TO THE CLERK.
EAST PRESTON
PARISH COUNCIL.

I am writing to you with great concern regarding a Planning Application being submitted by my immediate neighbour - Mr. CARL MERRETT.

15, THE PLANTATION. EAST PRESTON.

It is for internal alterations and roof extension.

Plans & Elevations As Proposed

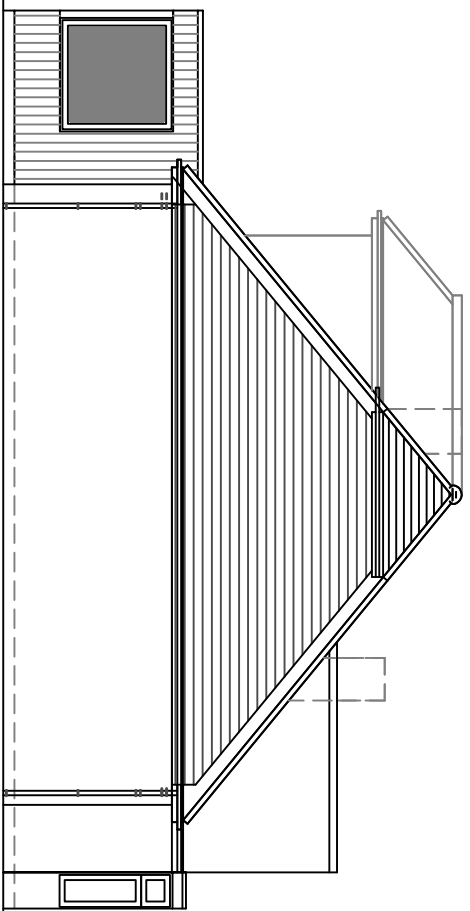
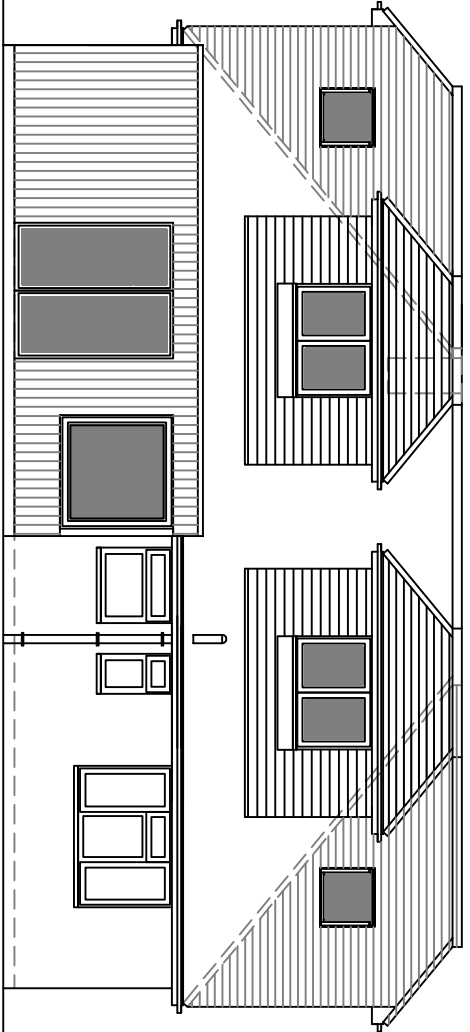
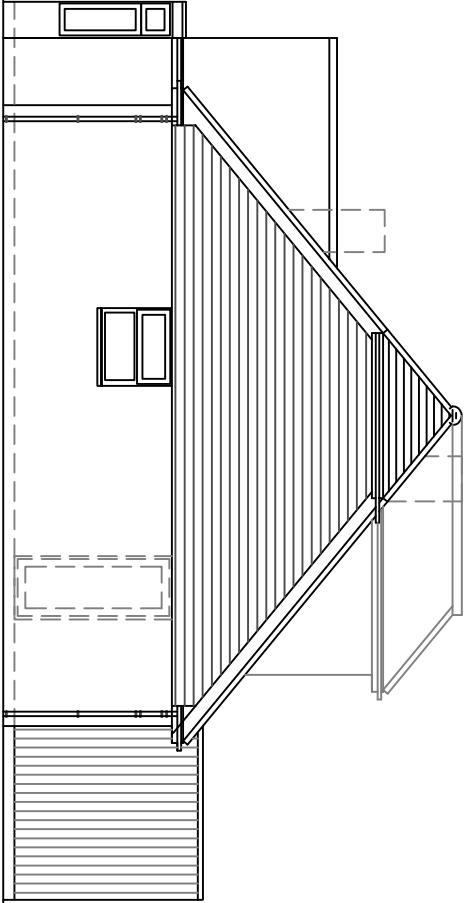
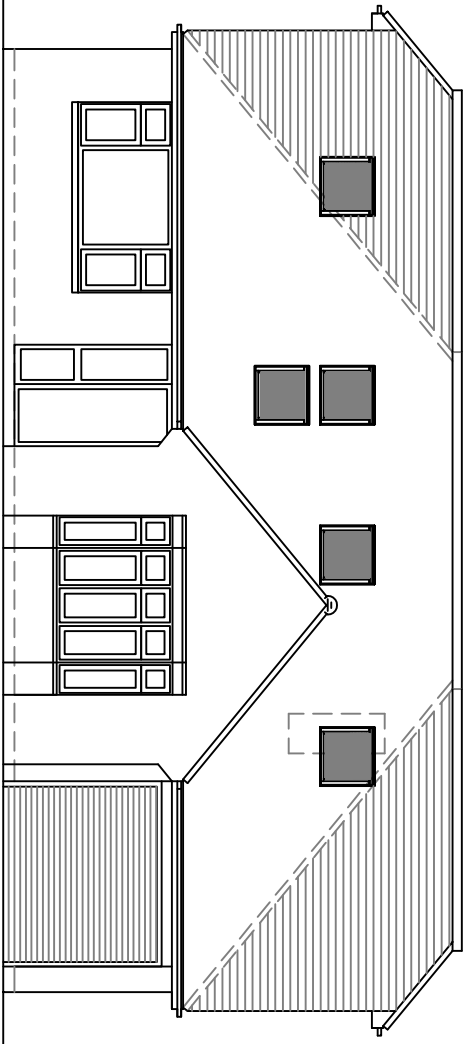
I have seen the plans and feel that the roof space is being over-developed and certainly not in keeping with the rest of the properties in our cul-de-sac.

At present, Nr 15, has peaked front windows and gabled ends, like the rest of the detached and semi-detached bungalows in this unique road.

The new plans show a over-bearing roof line with five windows at front. Two dormer and two windows at the rear - WEST.

My side - NORTH, will be over-shadowed by the height of the new roof extension, re-striking sun-light into my kitchen.
